August 26, 2008

RE: Corbett Short Plat (SP-08-00034)

Holly Duncan
Environmental Health Specialist
Kittitas County Public Health
(509) 962-758

CORBETT SHORT PLAT

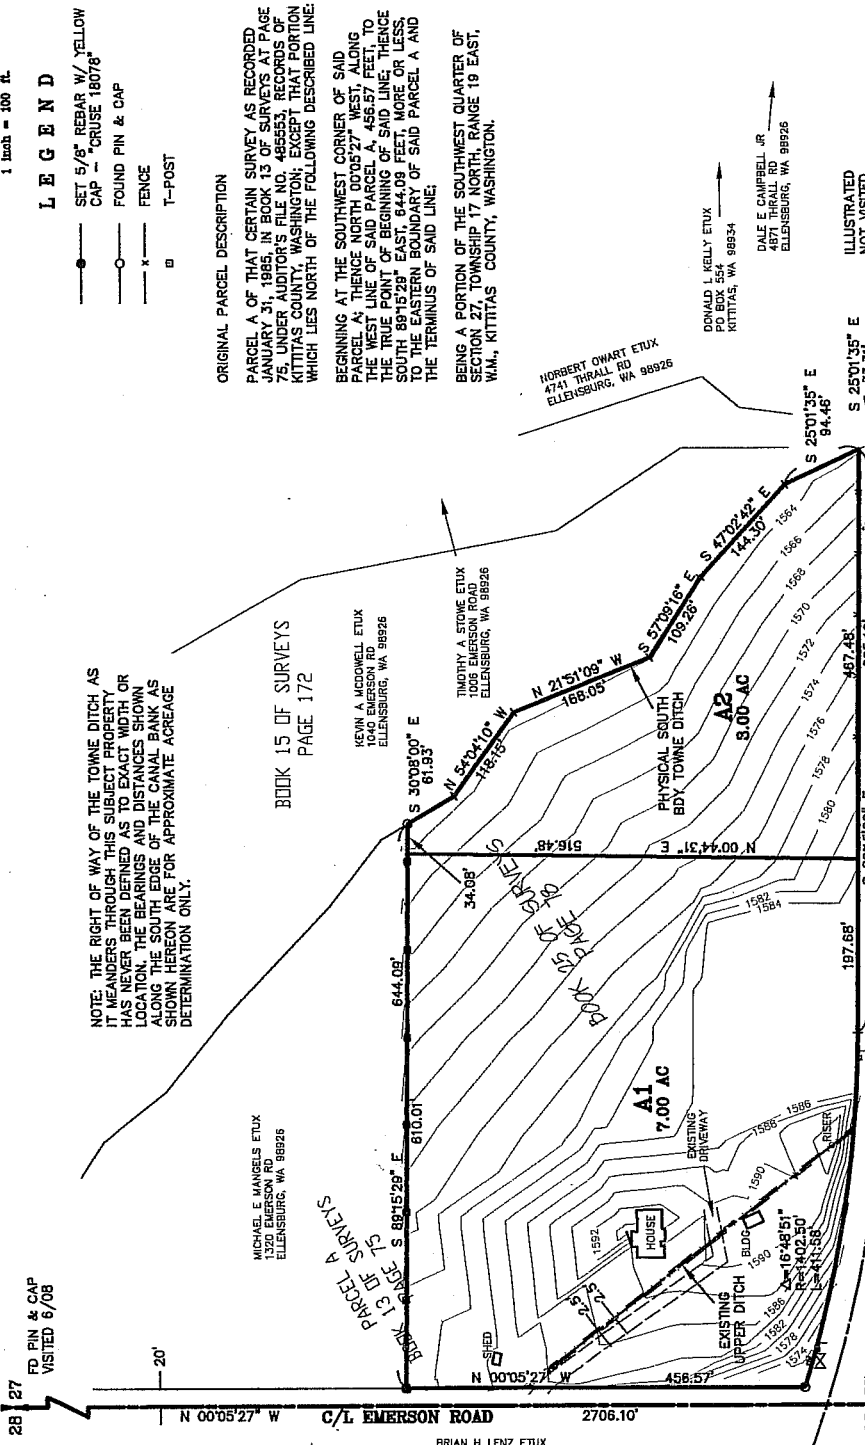
Thank you for the opportunity to comment on the above referenced project. The file indicates soil logs need to be performed and a well log is needed for the existing well on lot A1. A meter will be required to be installed on the future well drilled on lot A-2.
